From: Cruse & Associates <cruseandassoc@kvalley.com>
Sent: Wednesday, January 03, 2018 1:23 PM
To: Justin Turnbull; Chelsea Benner
Subject: Re: Woody BLA BL-17-00018
Attachments: Woody Property.pdf

Justin and Chelsea – Attached is an preliminary map of the Woody BLA survey updated to address PW comments. The area for Sisters Road right of way is included in both the title report and tax records for the Woody property. The owner would like to clean up the right of way but concerned he keep losing acreage. He does not want to alter the south boundary of Parcel 1 that has been established. I am hoping CDS will approve this layout of 9.95 acres recognizing it is 10 acres as originally described but losing 0.05 acres to clean up the Sister Road Right of Way conflict. I added note 13 to clarify this issue.

WOODY PROPERTY

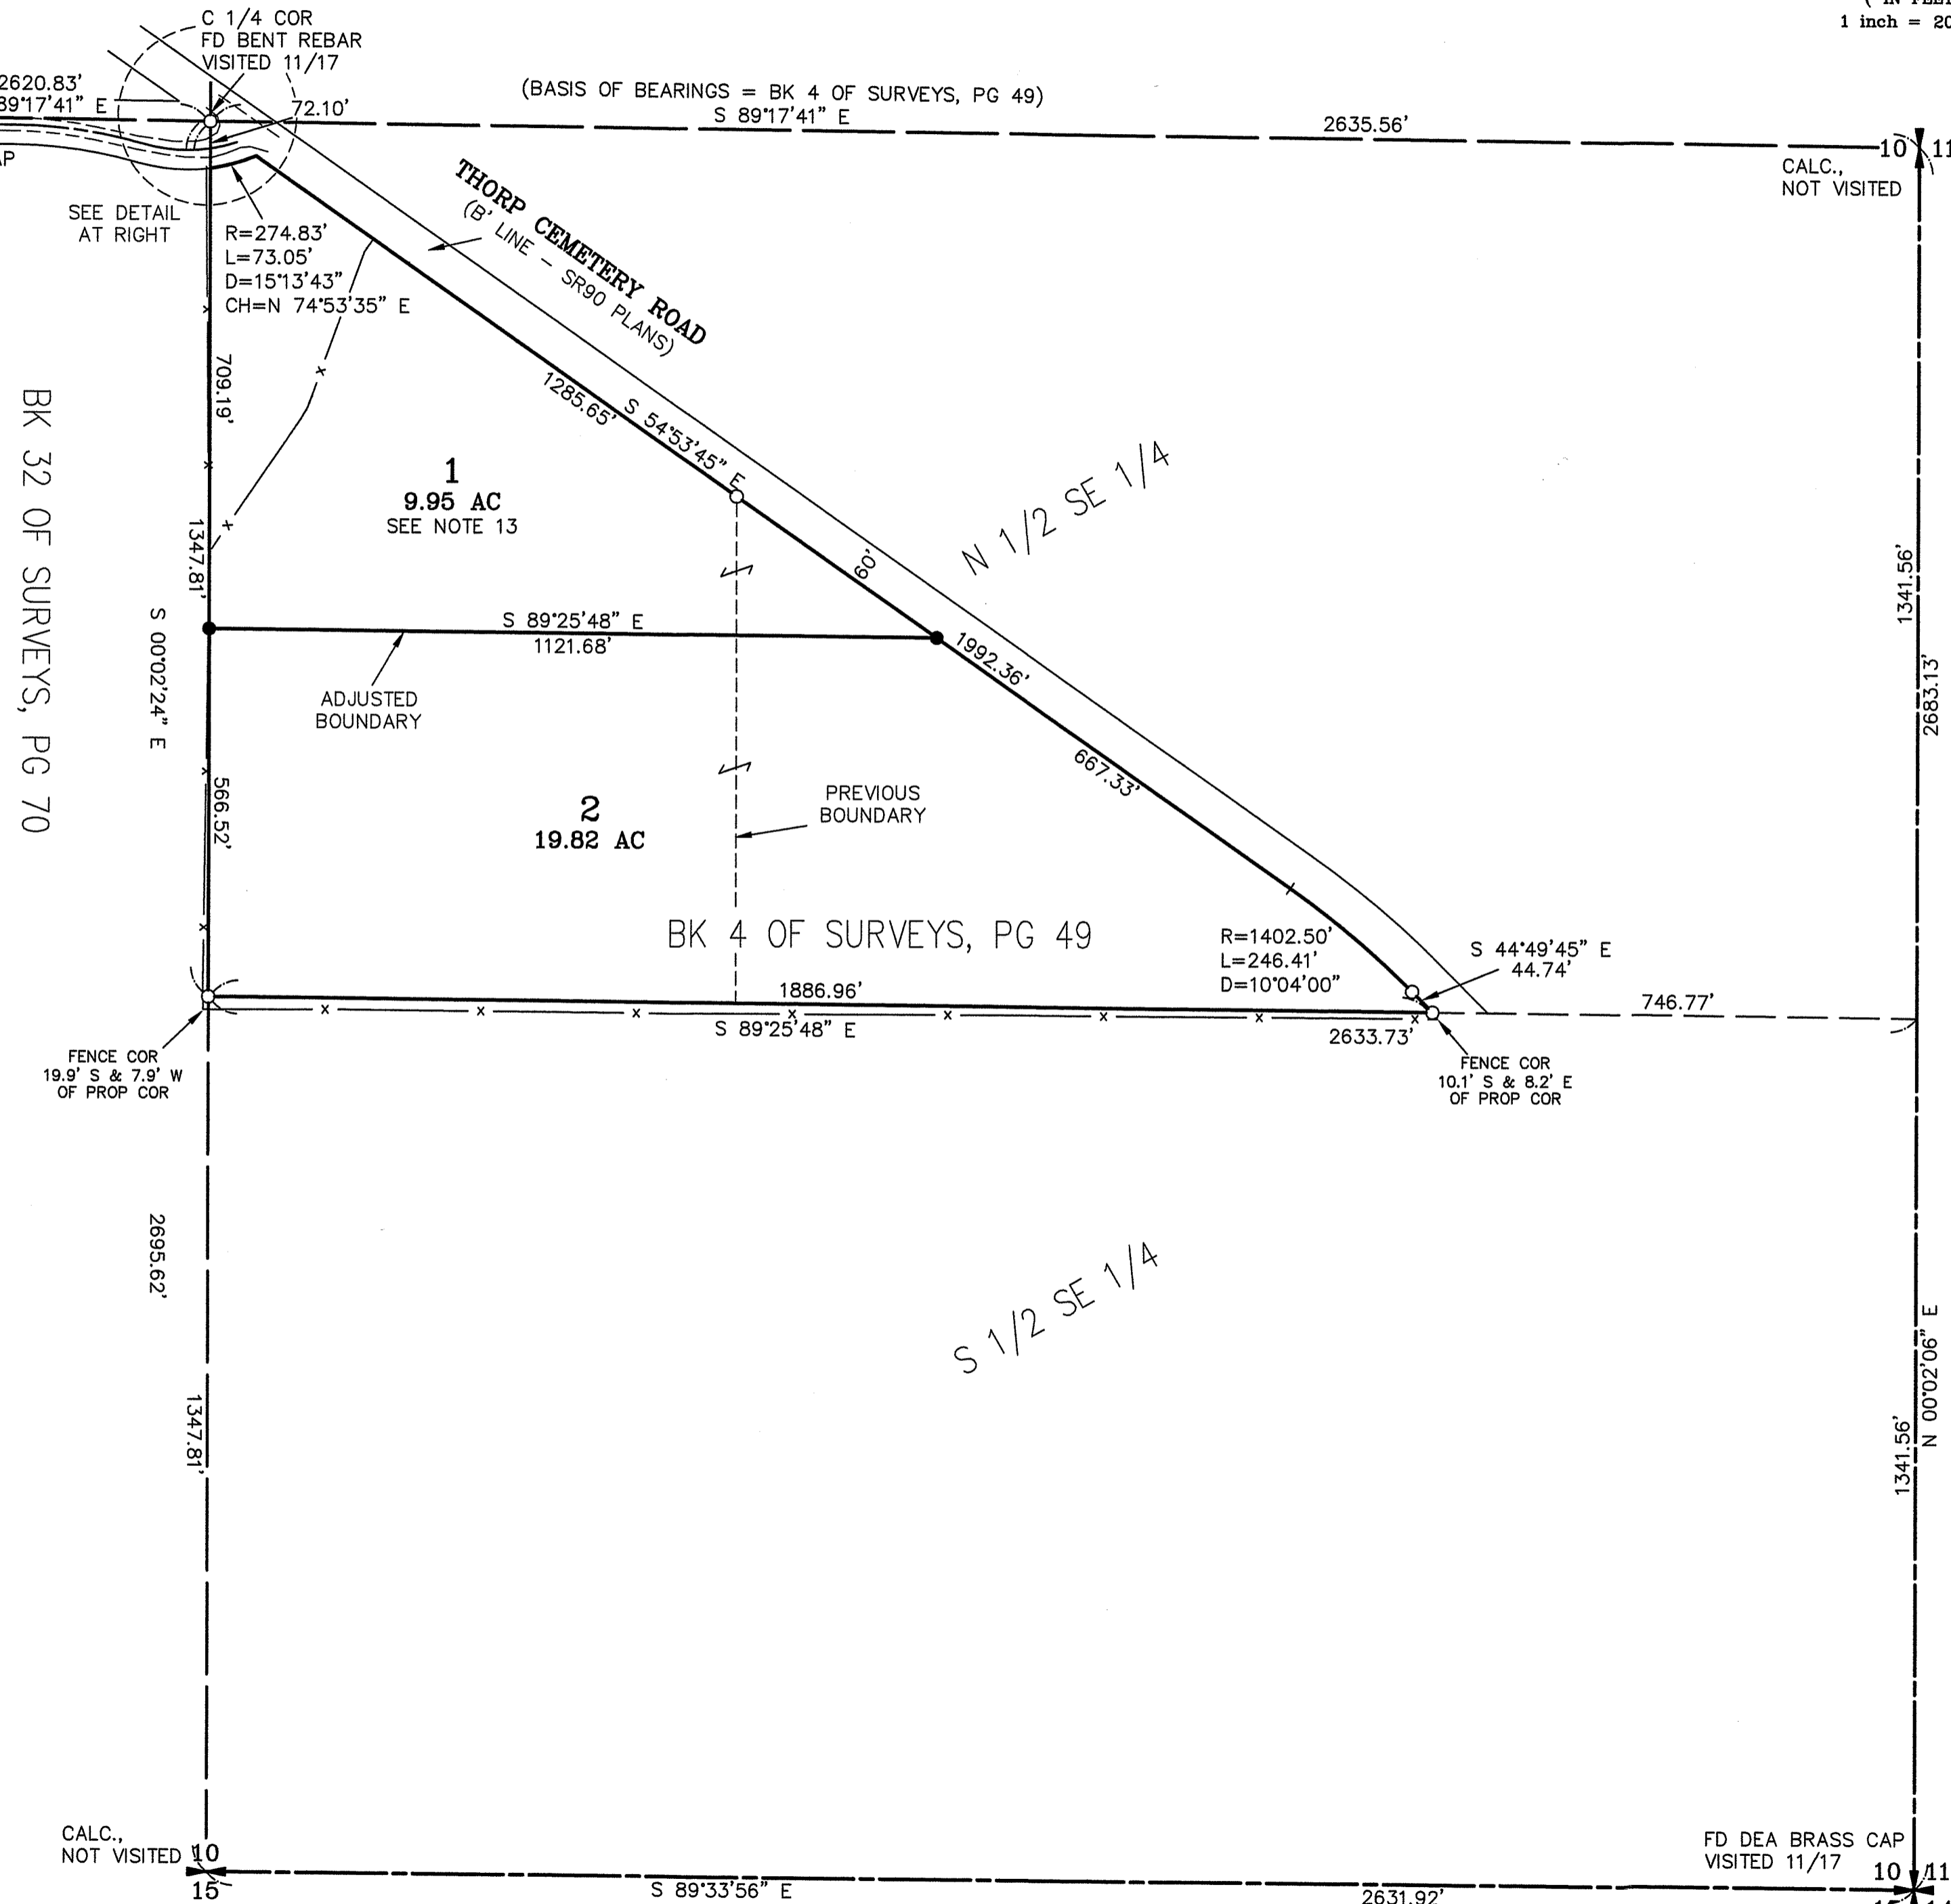
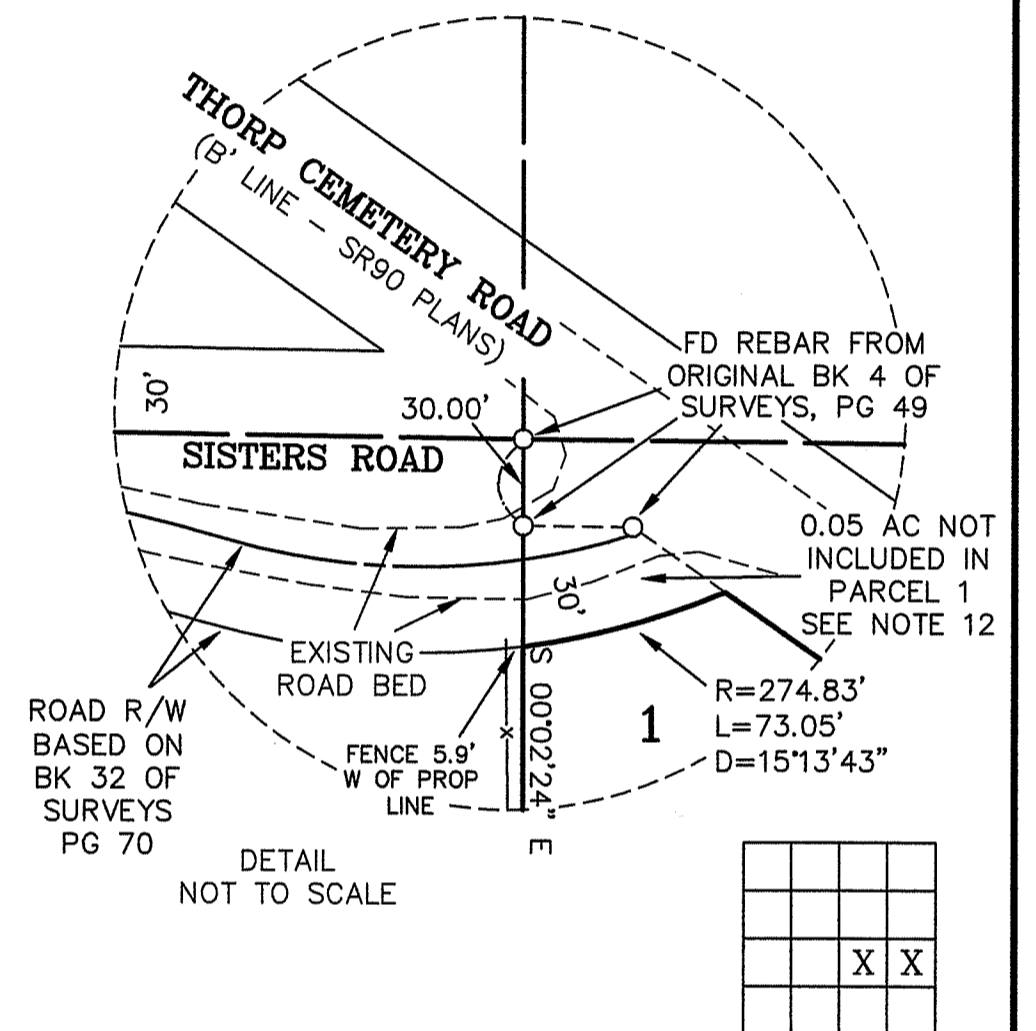
If Parcel 1 needs to be 10 acres I will add the right of way back into the parcel and address the Sisters Road right of way conflict with a note. Please review and contact me back with any questions/concerns or notice to proceed and we will record.

WOODY PROPERTY

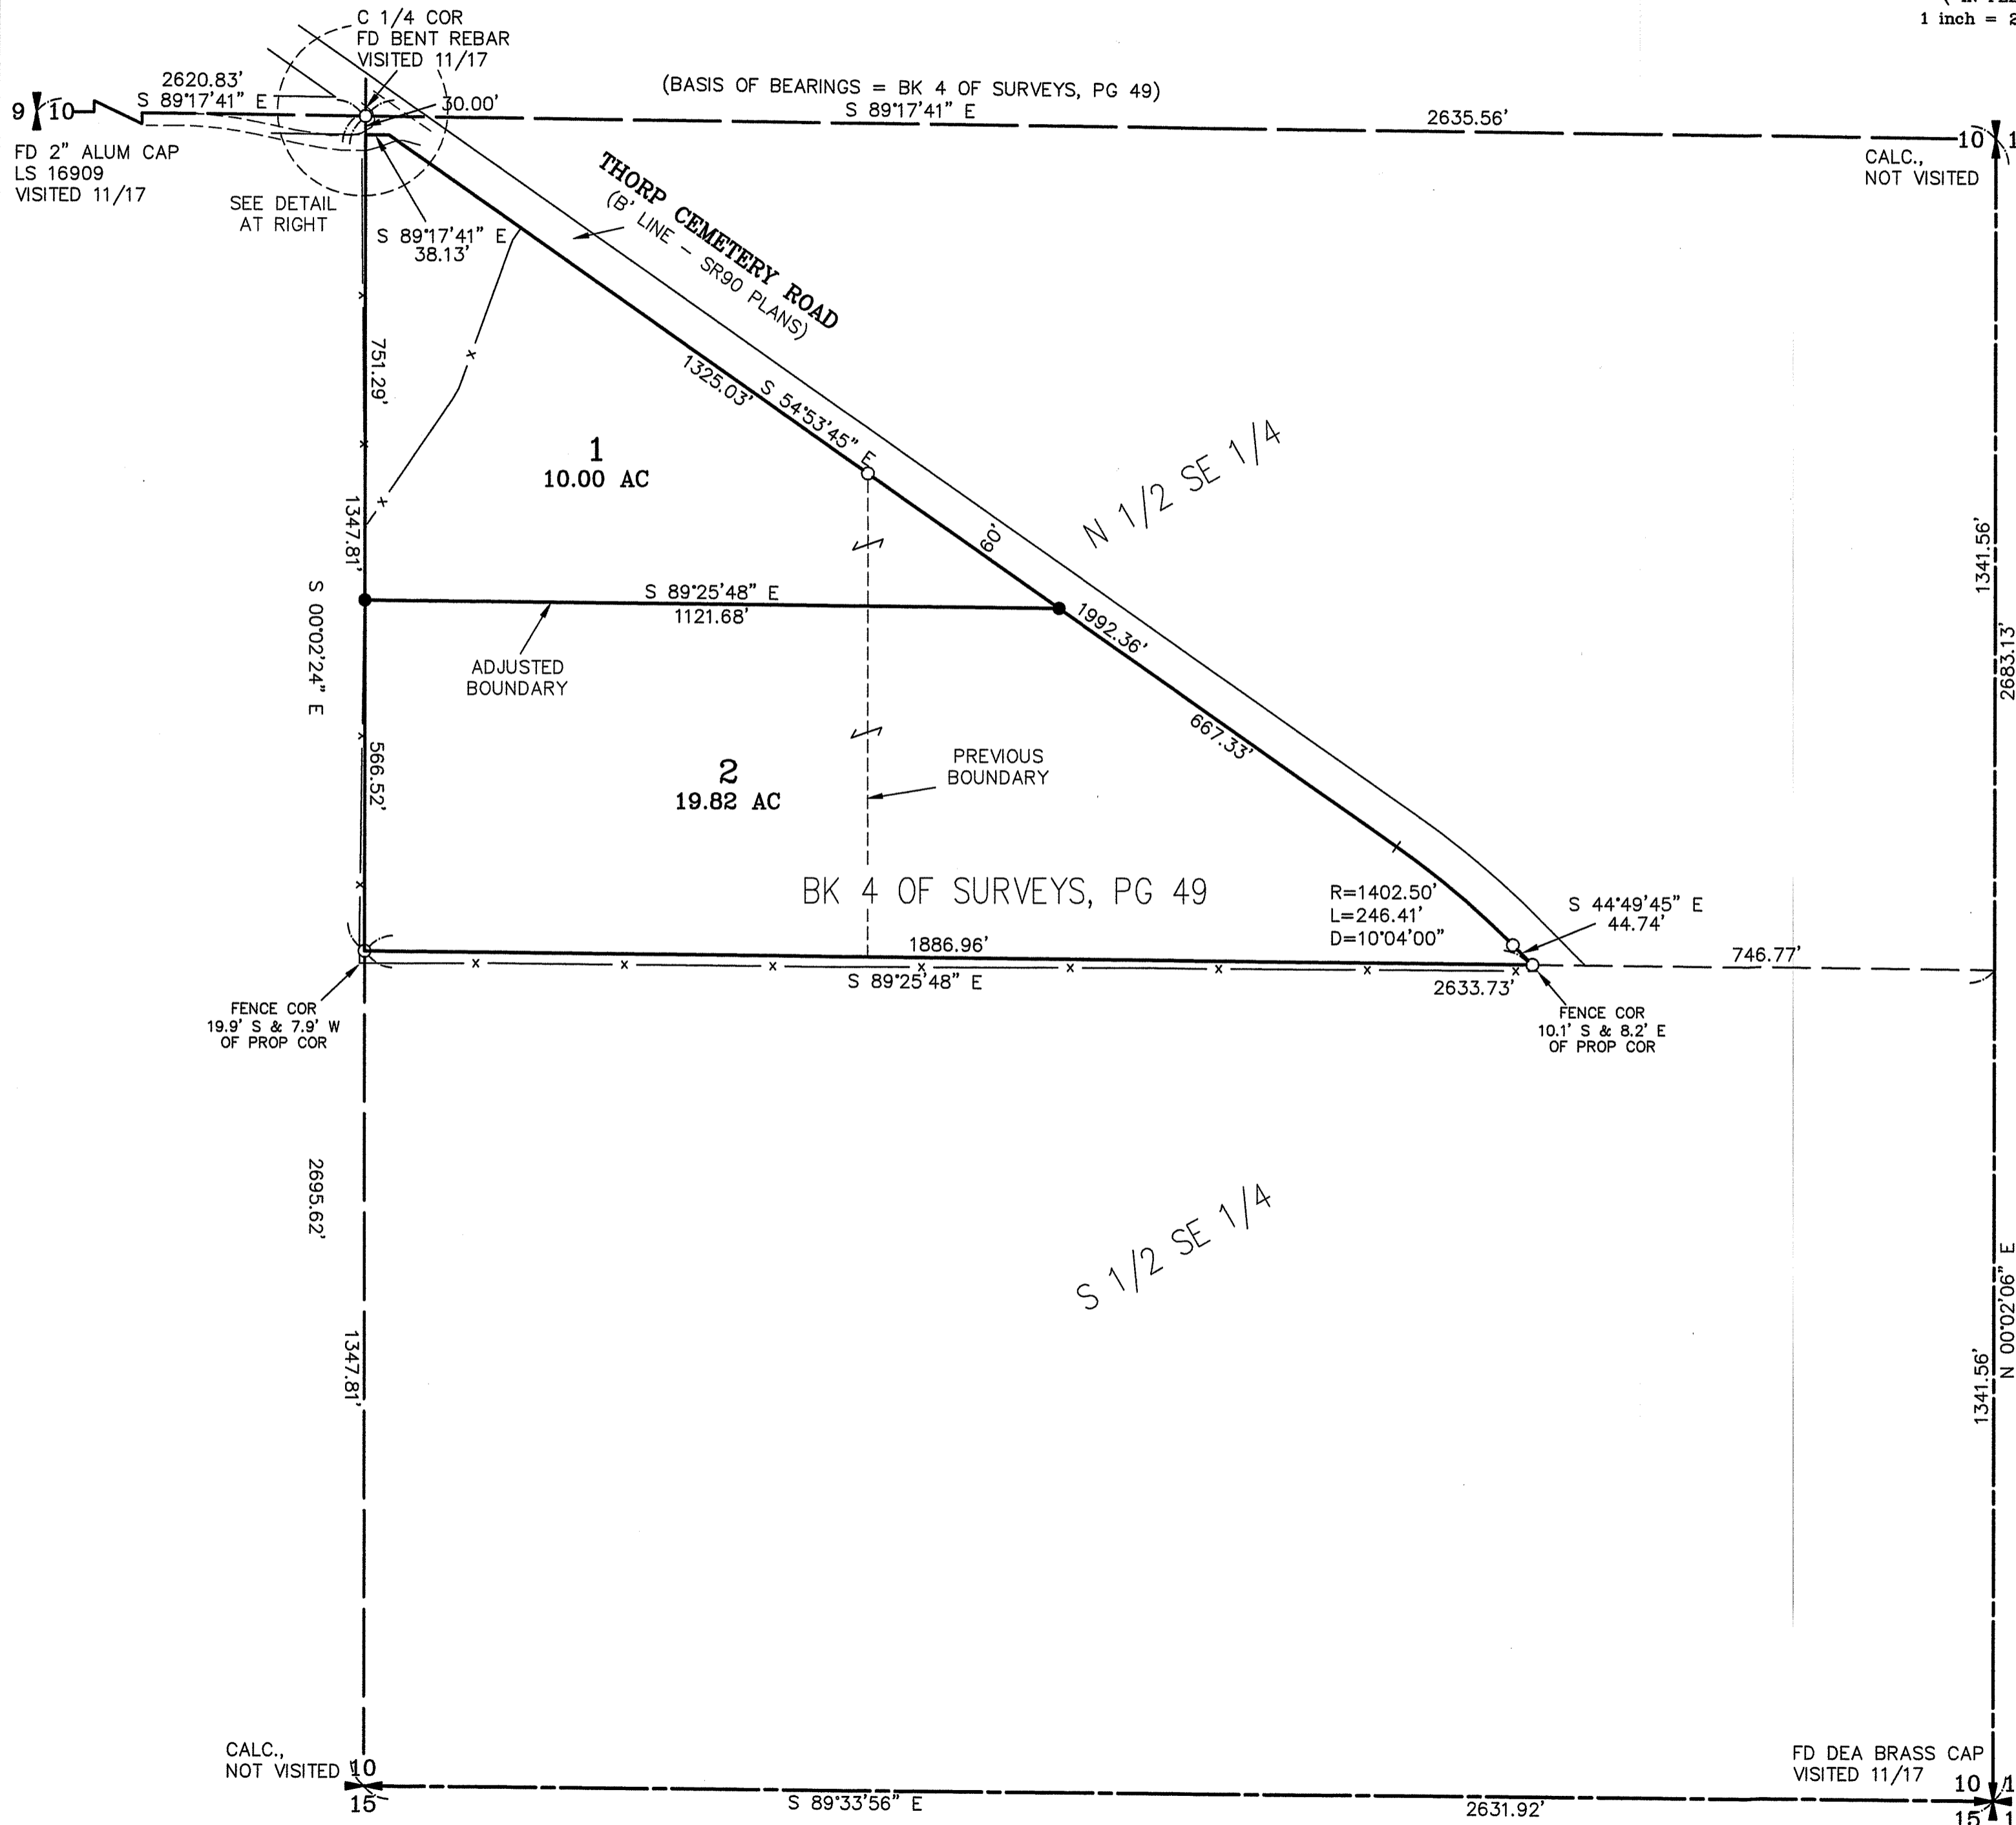
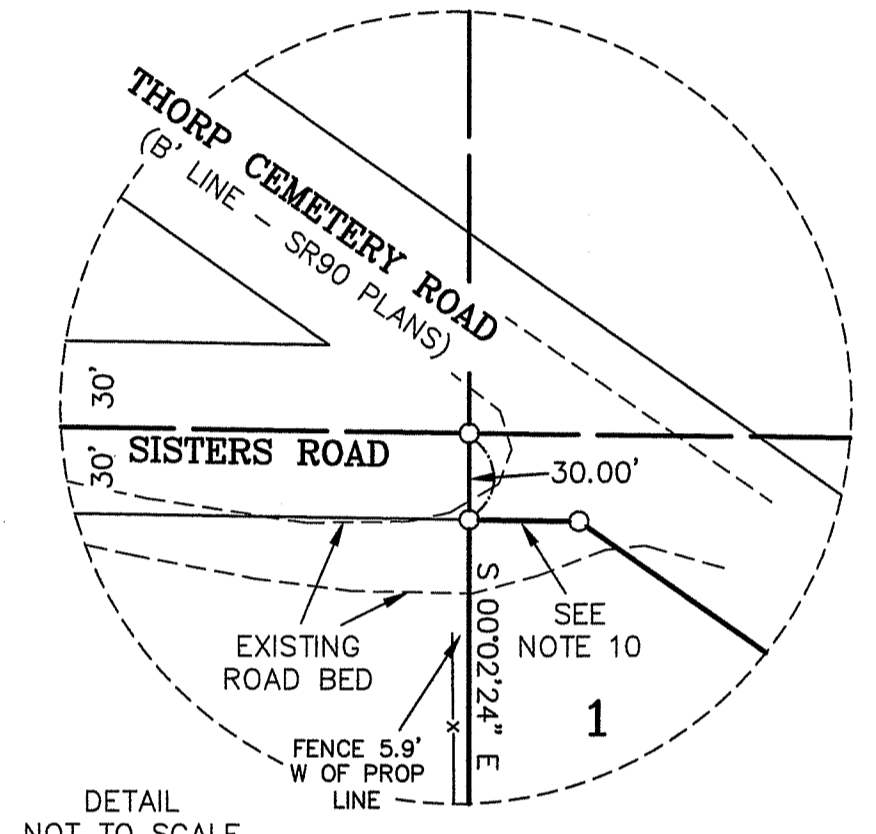
Chris,
Our records fail to mathematically describe the roadway in any form. We have visual representation of the roadway for utility franchises from 2015, 2008 and 1974 all showing the road bending, and Aerial photography from 1954 show the bend in the road as occurring prior to the construction of I-90.

Sunquist performed an adjacent survey in 2007 and shows the roadway clearly bending and holds the roadway as not being centered about the section line..

From my records, the lack of documents creating the roadway (deeds or road grants), combined with the long history of the road bending, leads me to lean towards centering the Right of way about the existing roadway, and holding a 60' R/W by prescription per RCW:36.75.070.

It appears that the only survey in disagreement with this is Skinners survey from 1977.

Justin – I am holding the original surveyed boundary as it exactly matches the title report I purchased for this application. It is not disclosed on the original survey but my crew found the original property corners from 1977 in the the asphalt road bed for Sister (Goodwin) road. The title report did not reference any deeds or other documents that would relocate or enlarge the Sisters Road right of way. Not a legal document but the attached 1965 SR 90 plans also illustrate the existing road was outside of the right of way. Could you please search your records and see what additional information you can find for this intersection that may locate the right of way to better match the current road location.
